3/2022/0279 and 3/2022/0278 Talbot Hotel Chipping

**Subject:** RE: 3/2022/0279 and 3/2022/0278 Talbot Hotel Chipping

4. Talbot Hotel – the replacement extension has been omitted to retain the existing. As mentioned I have removed the modern and unsympathetic hipped roof to continue the existing section of parapet roof style which I feel better reflects the existing and exposes more of the external wall and dominance of the former roof structure.

6521 - P05 REV **A**

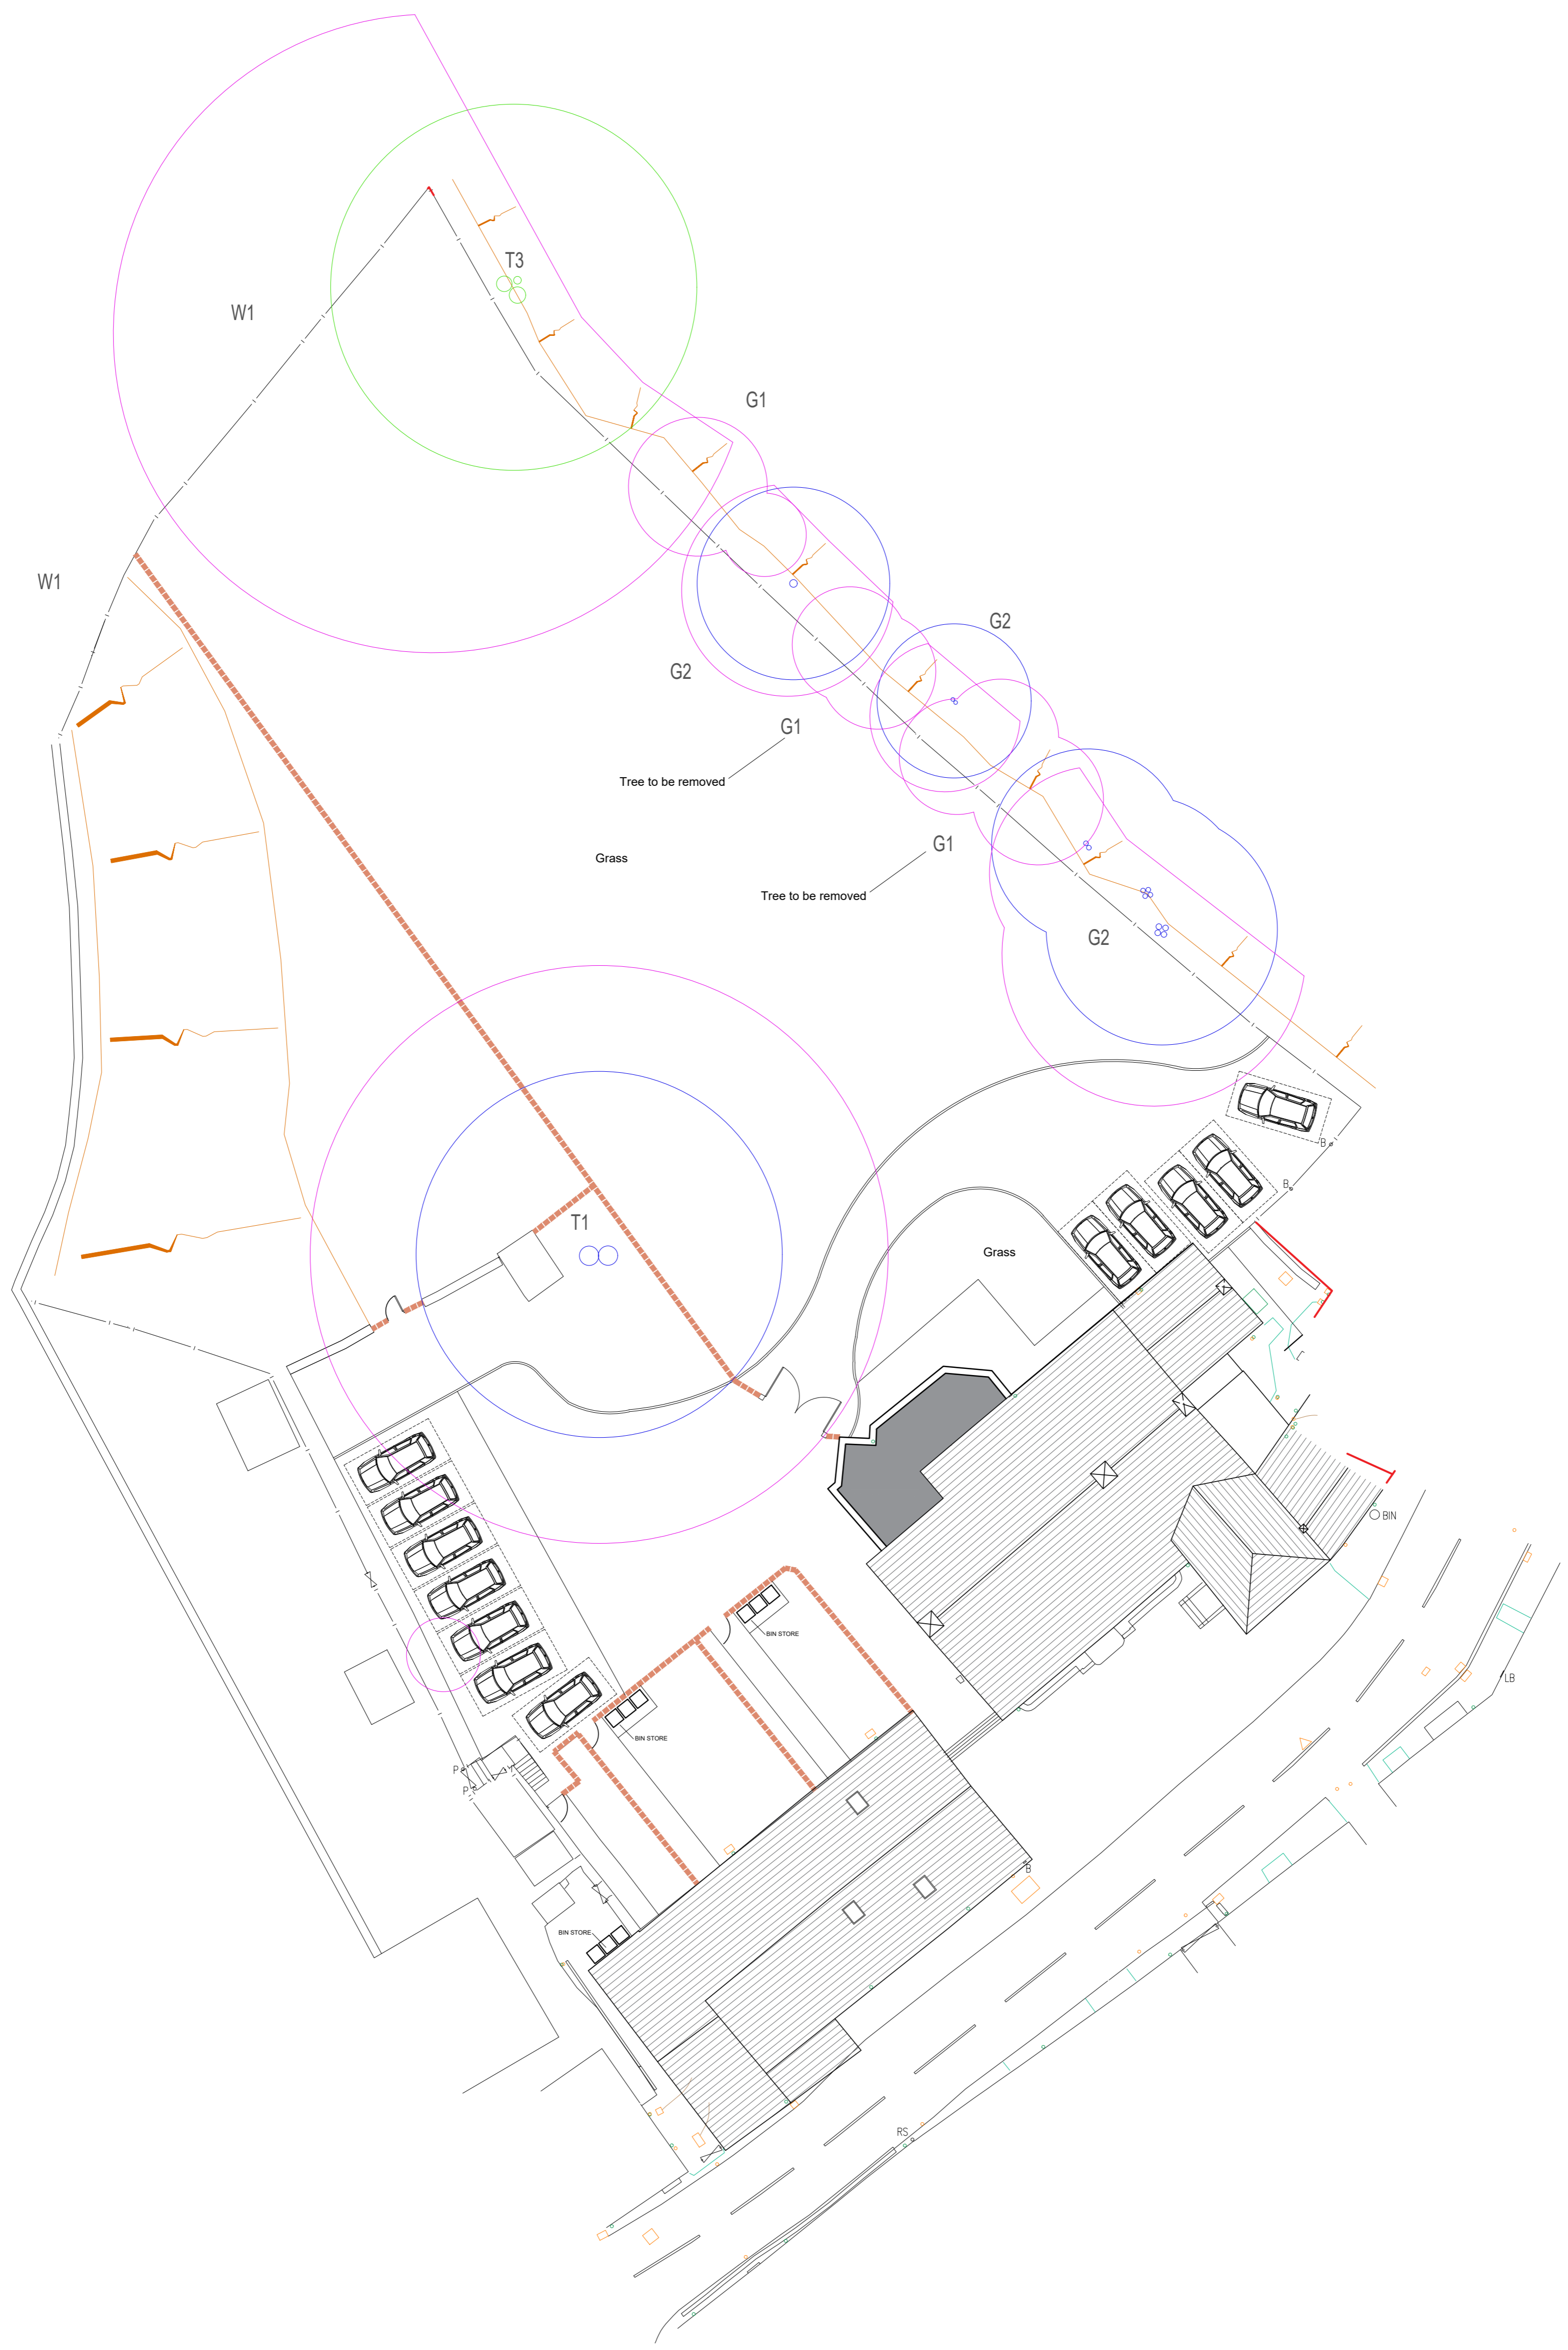
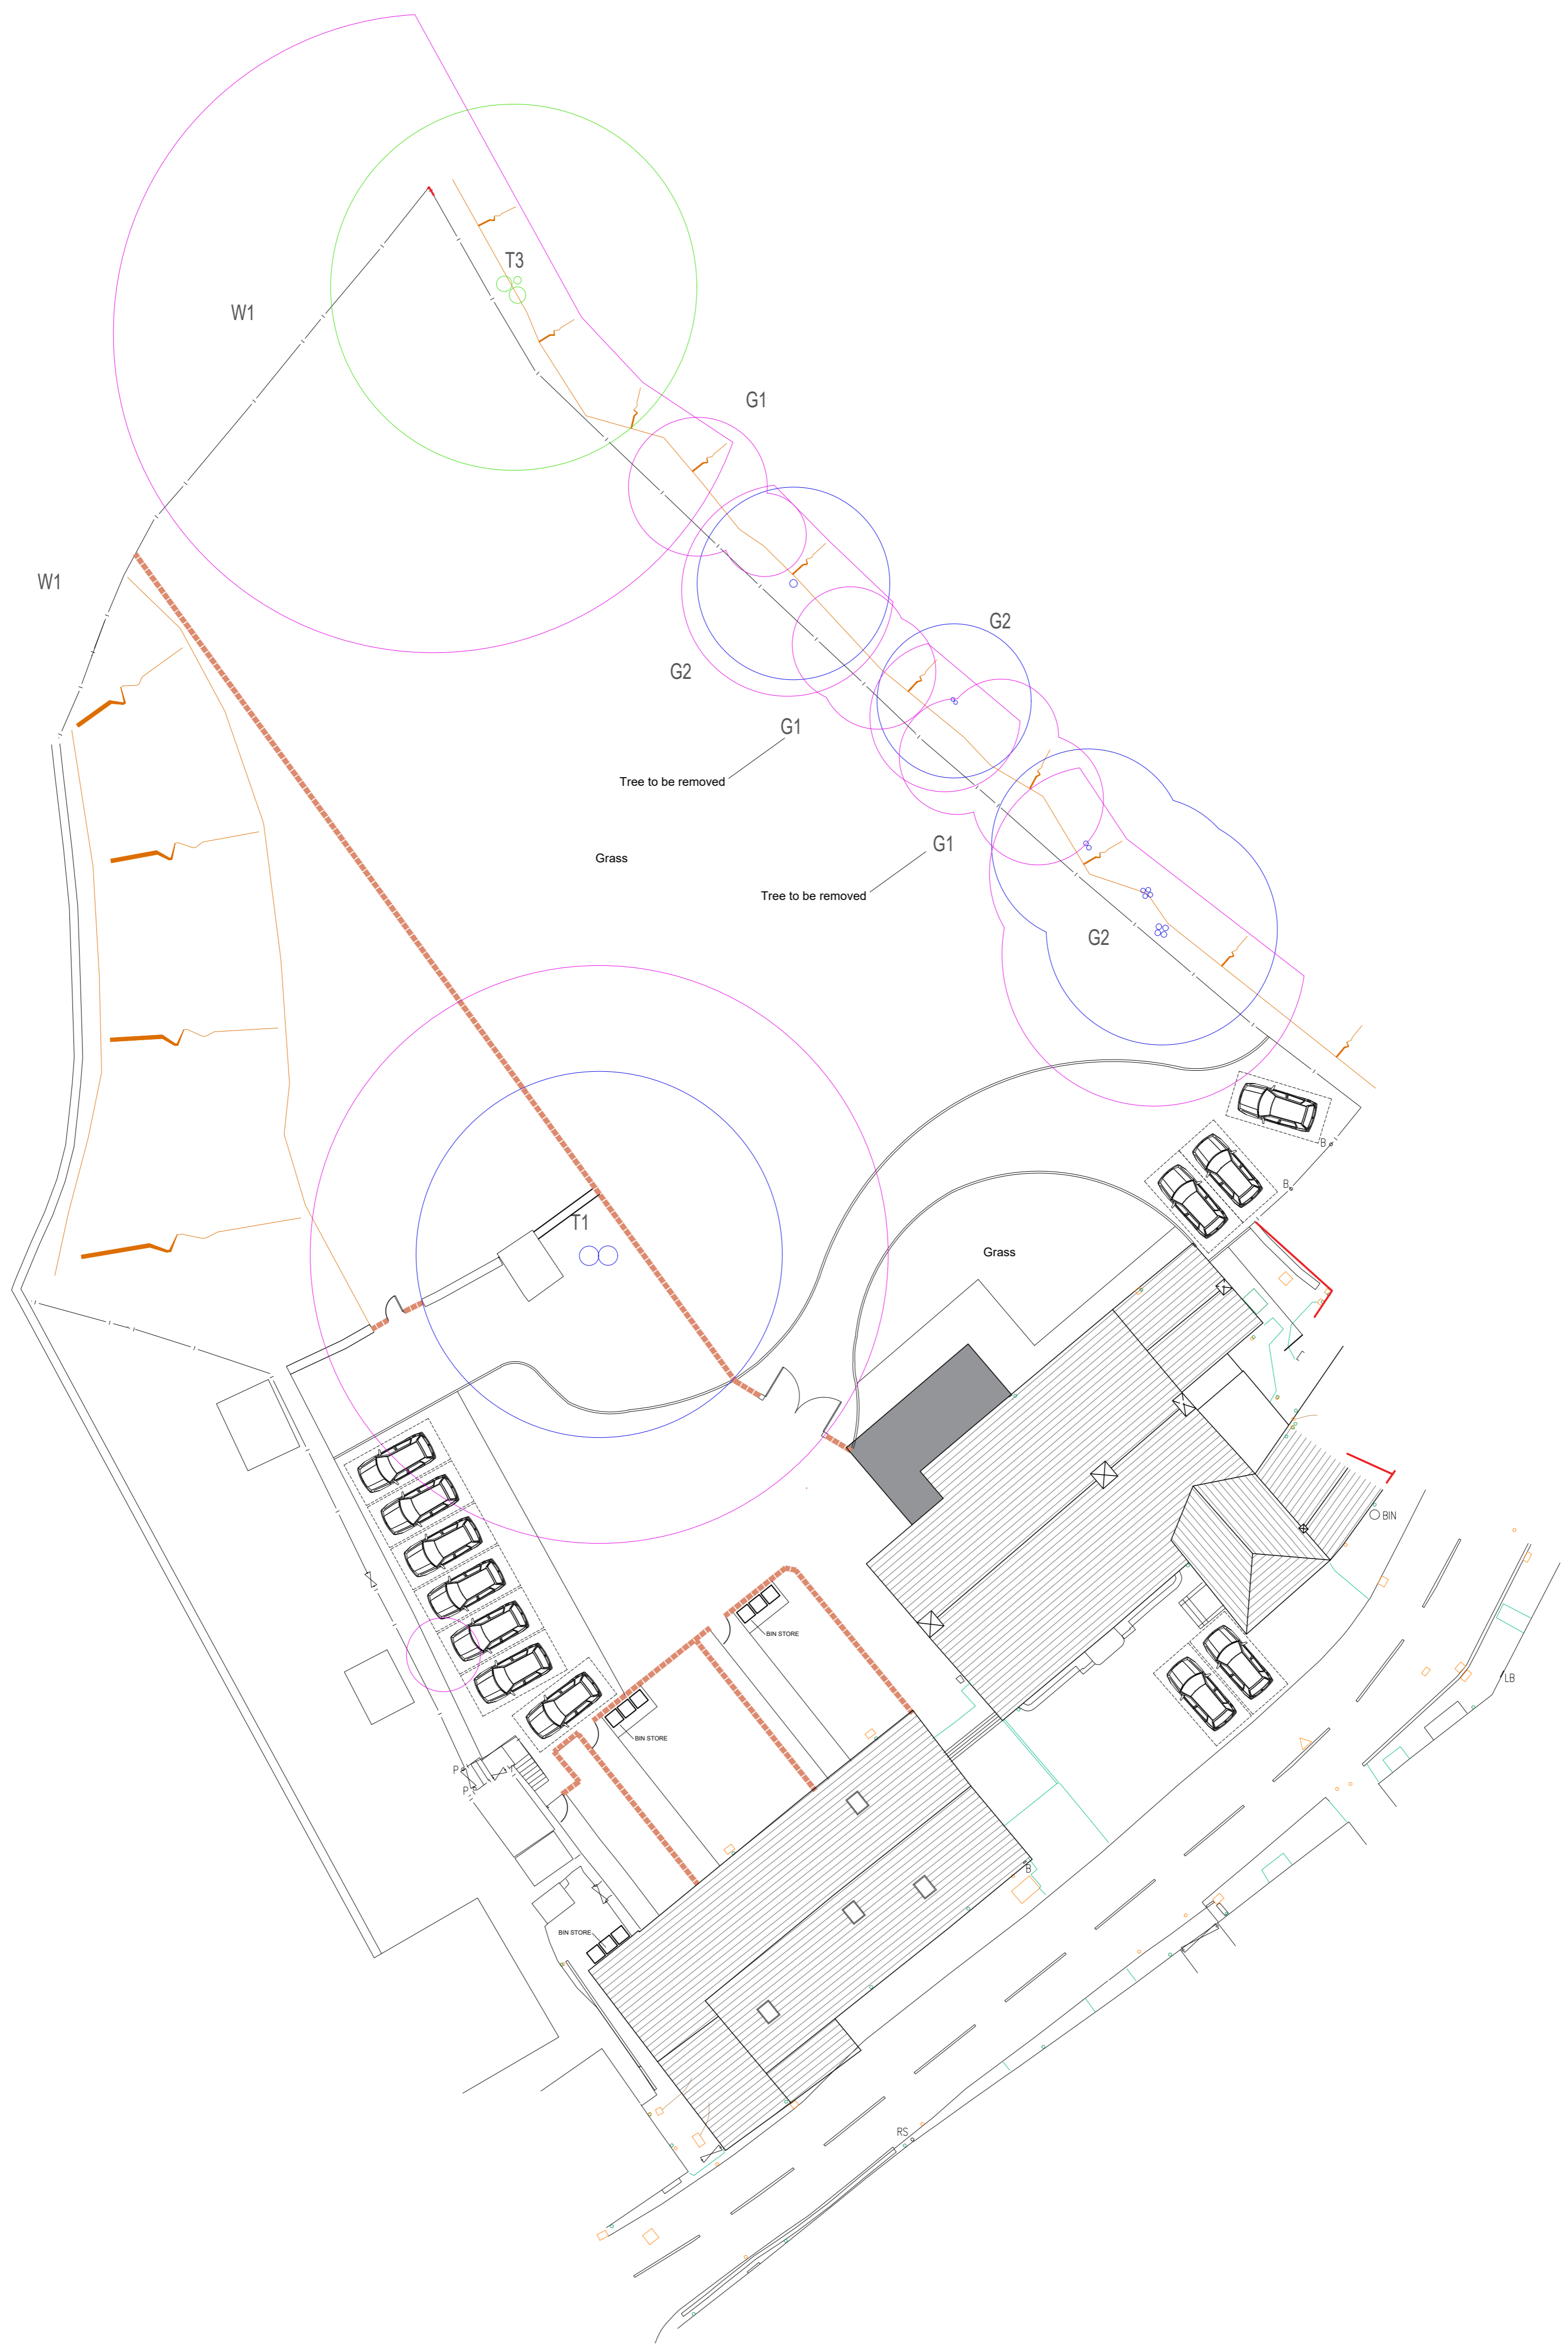
7. Holiday let parking relocated to the rear as requested by LCC.
